3/2012/0501

Response from Bashall Eaves and Mitton Parish Council

PORTAL FRAME BUILDING.

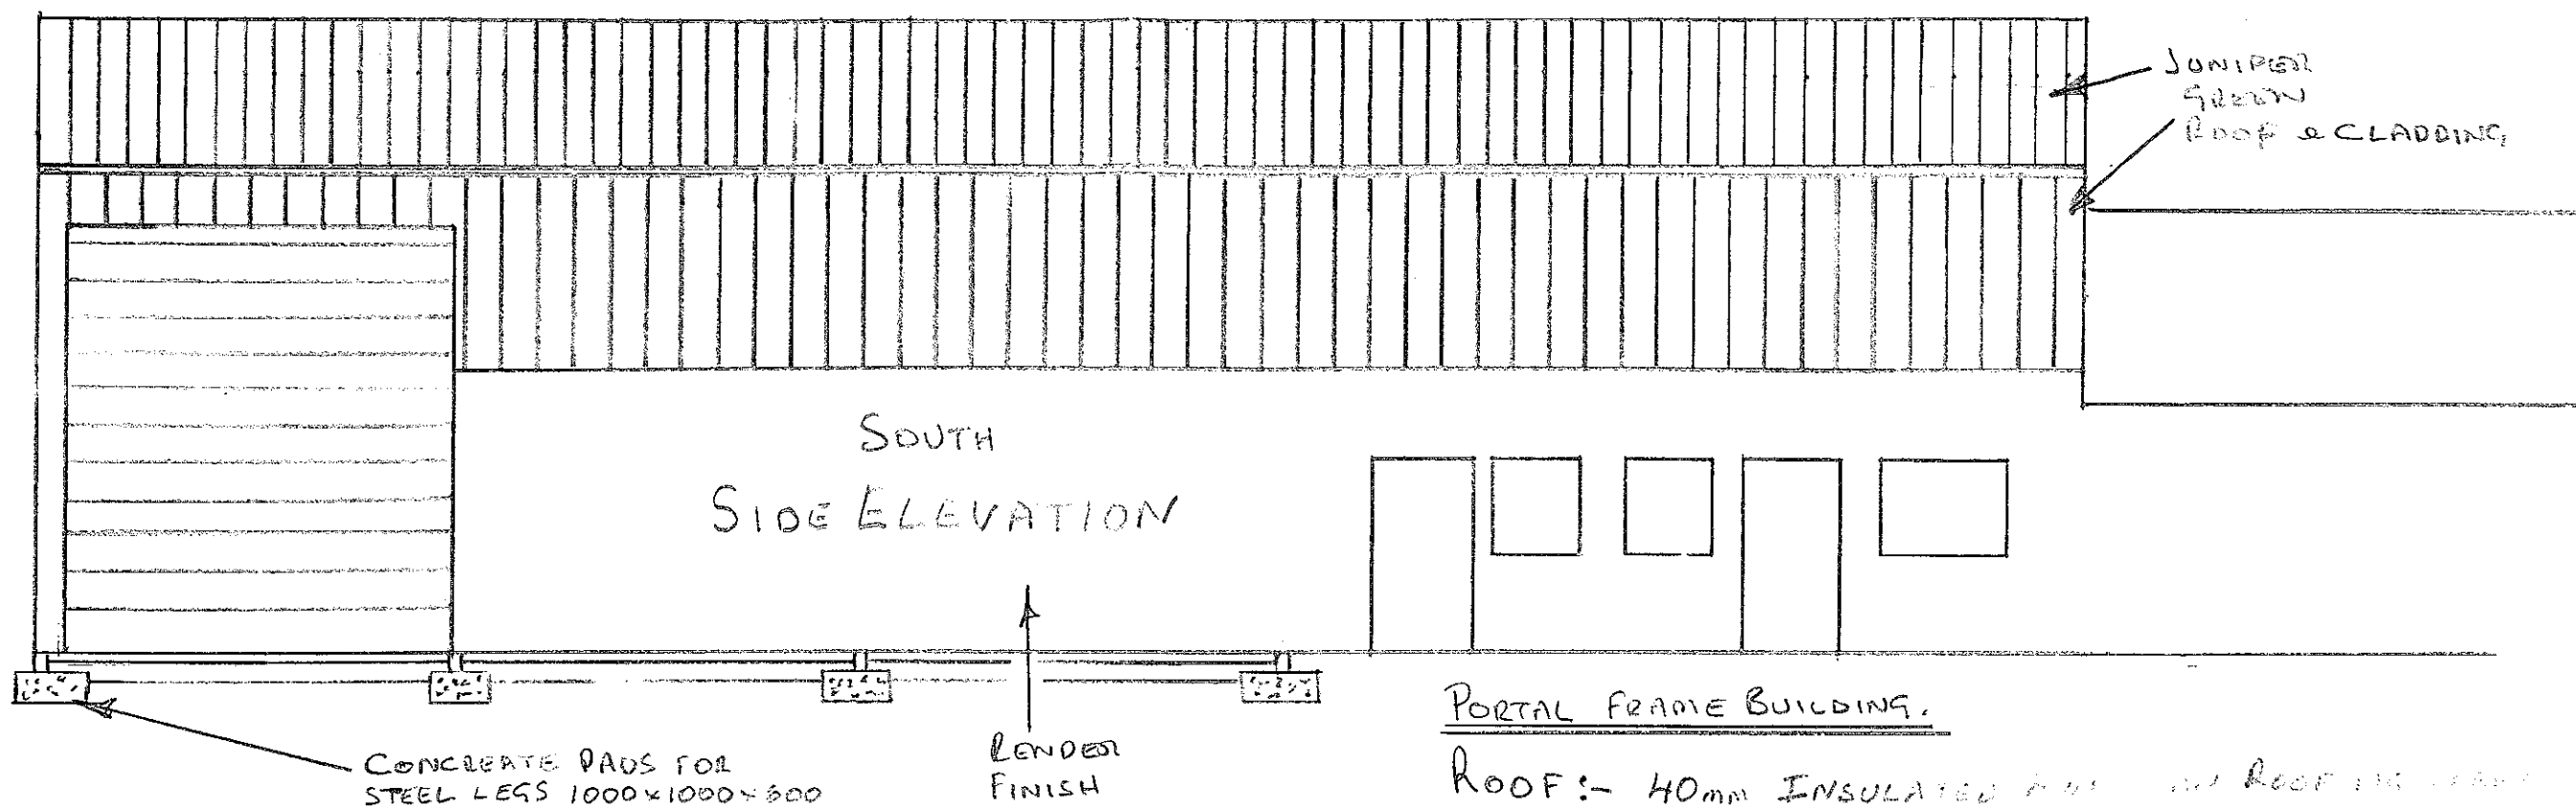
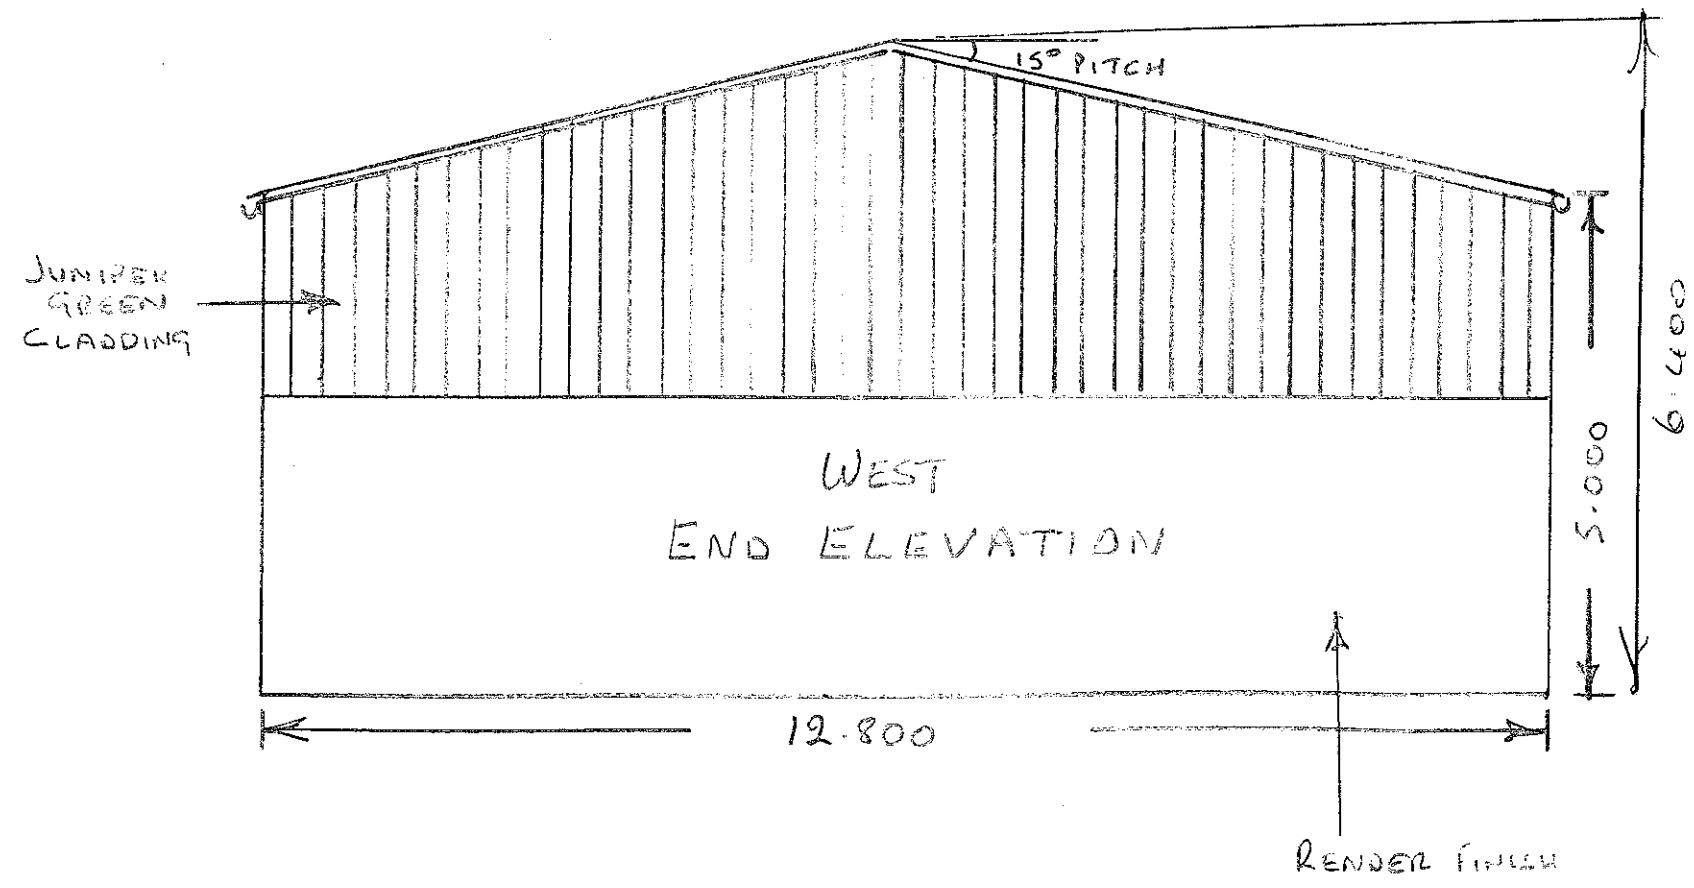
1 The scale is out of proportion to any surrounding buildings. From Mitton Church it is clearly visible and destroys the otherwise rural scene.

2 A building of this scale is intended as a rather major manufacturing enterprise (much more significant than the "dog kennel manufacture" in the application). Several employees conducting metal-working and associated activities will lead to unacceptable noise and disturbance in a rural environment.
